From: Laura Gibbons <Laura.Gibbons@arun.gov.uk>
Sent: 31 August 2021 08:47
To: Planning.Responses <Planning.Responses@arun.gov.uk>
Cc: Anita Gardner <Anita.Gardner@arun.gov.uk>
Subject: FW: Planning Consultation on: M/104/21/DOC

Engineers Comments Regarding Condition 3

Application No: M/104/21/DOC

Description of Works: Approval of details reserved by condition imposed under M/103/20/HH relating to condition 3-surface water drainage scheme.

Drawing Title
Drainage Layout

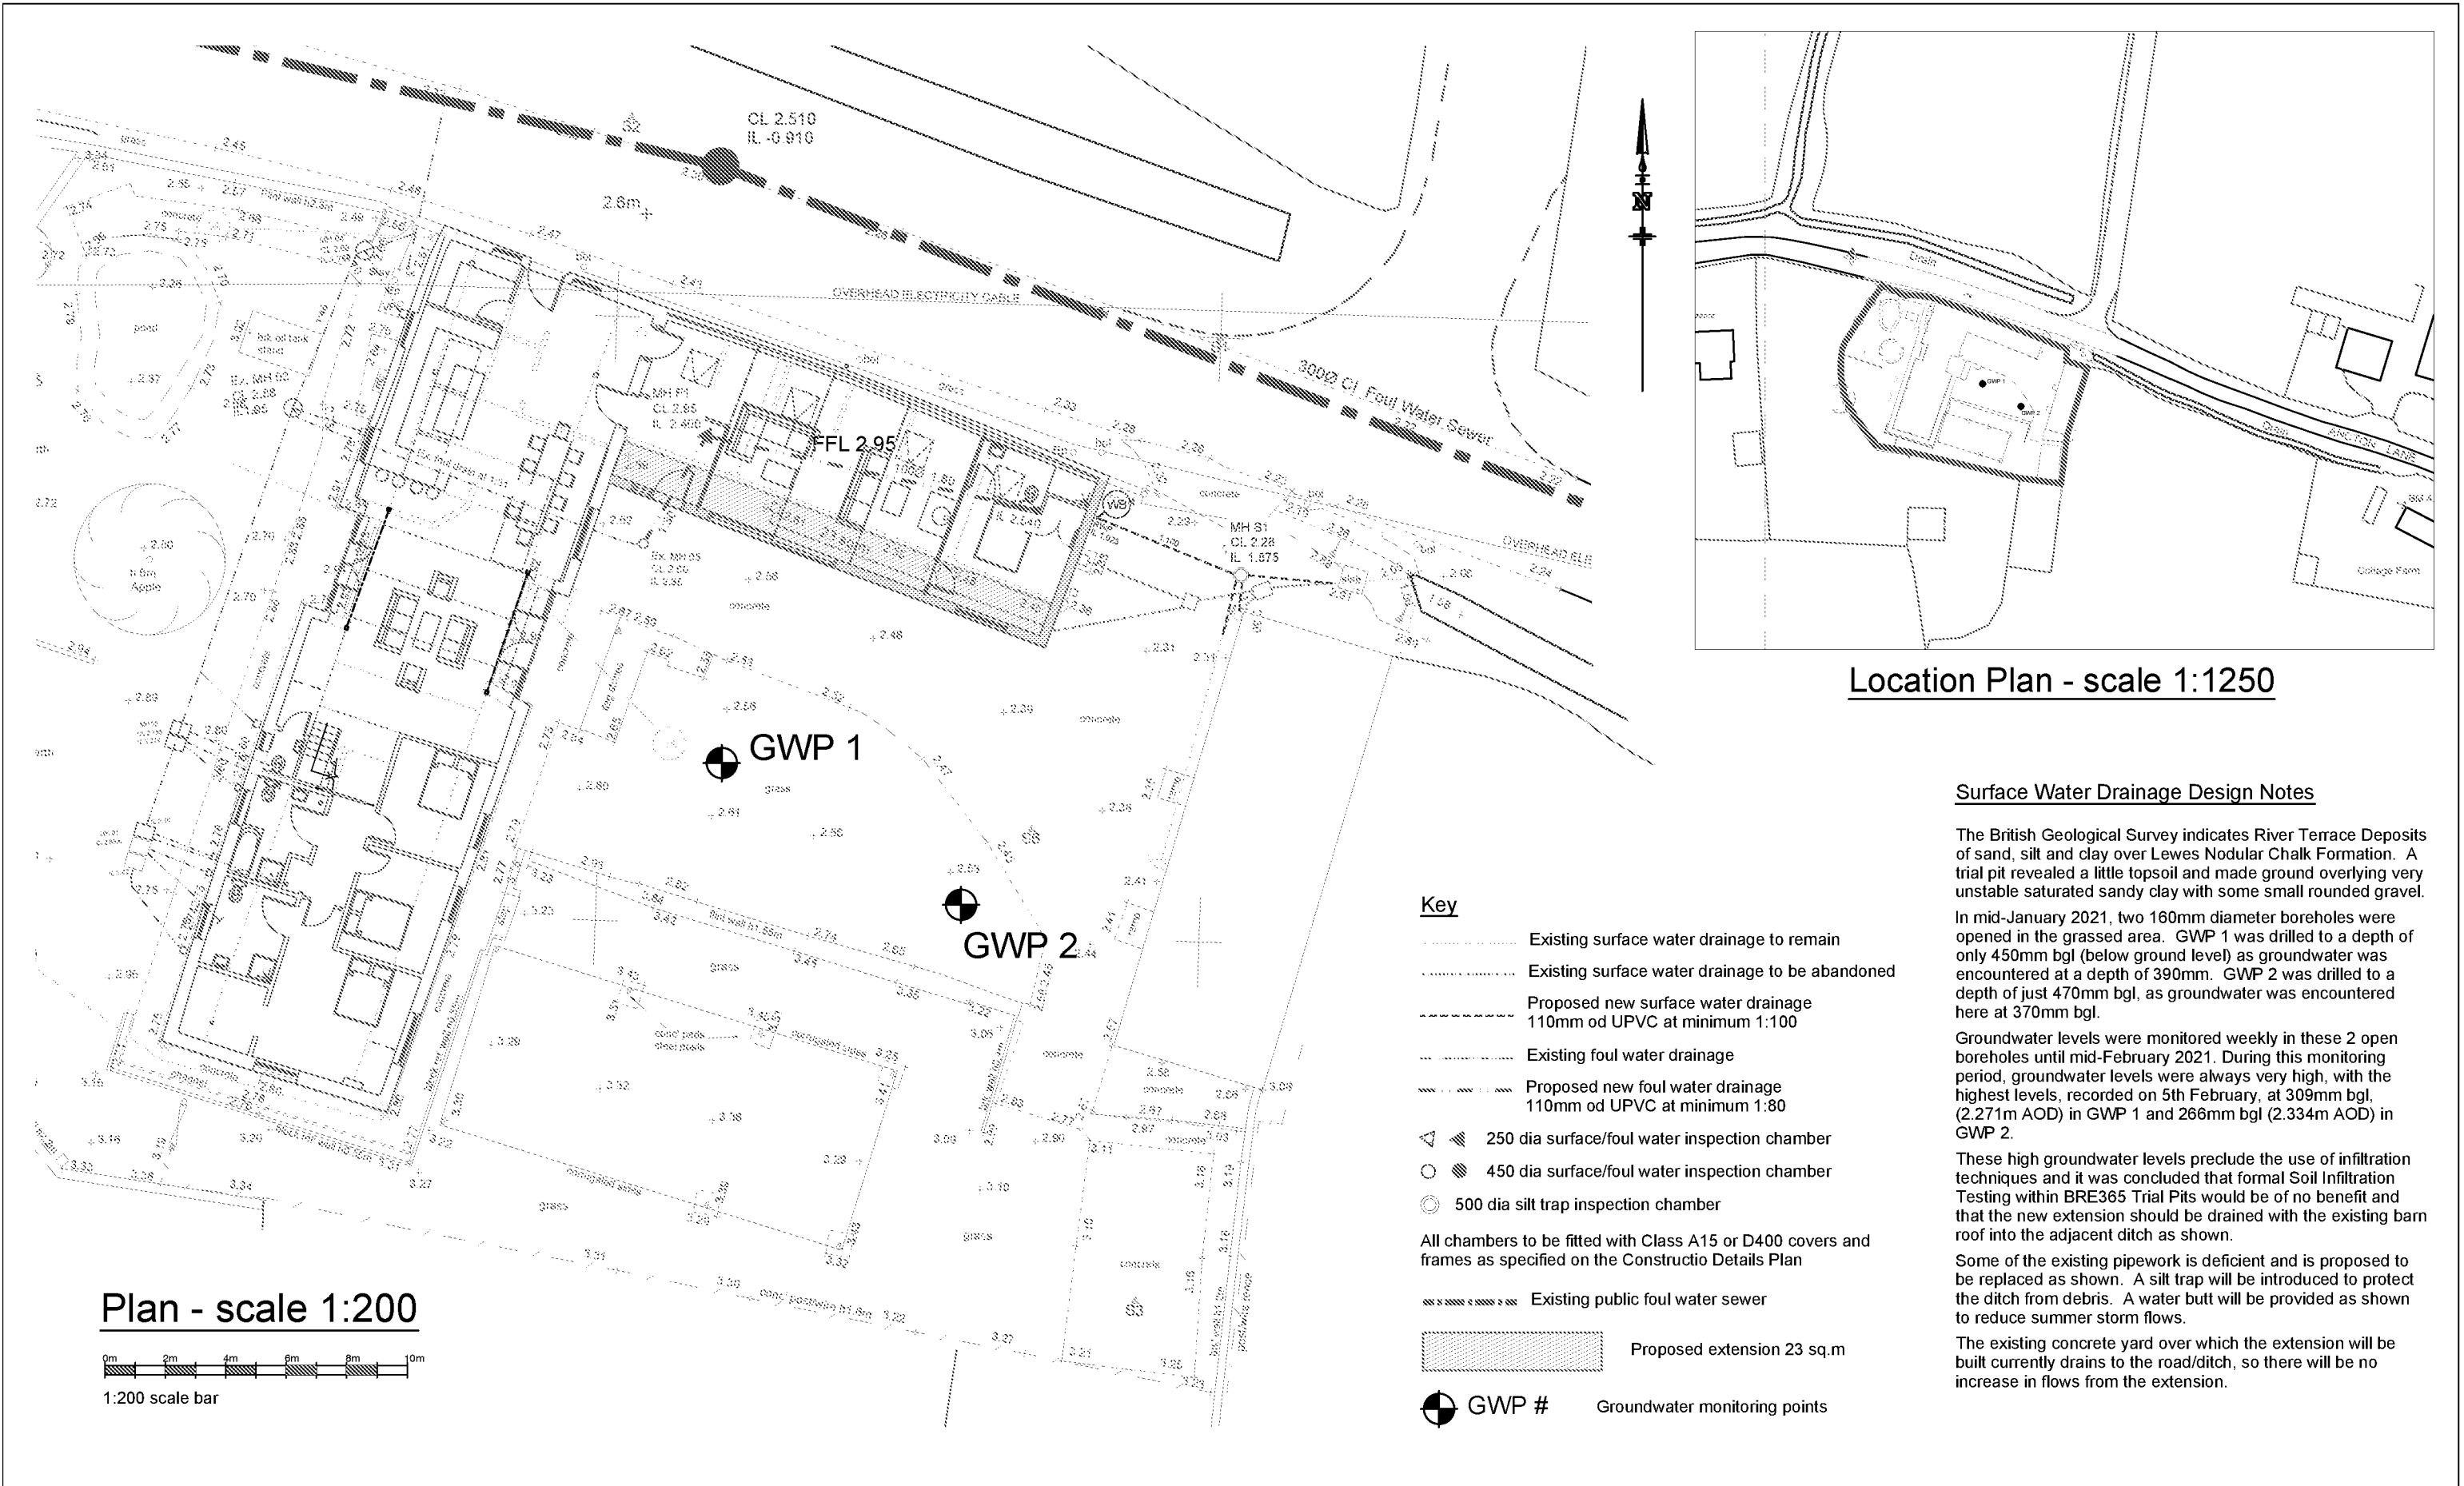
It is noted that winter groundwater monitoring has been completed and groundwater was found very shallow. A check of discharge rate from the proposed extension area indicates that the flow rate would be lower than that safely obtainable via a flow restriction device, it is also noted that the area was previously impermeable, therefore discharging unattenuated to the watercourse is acceptable.

I recommend discharge of condition 3. Please ensure that the following plans are listed on any approval:
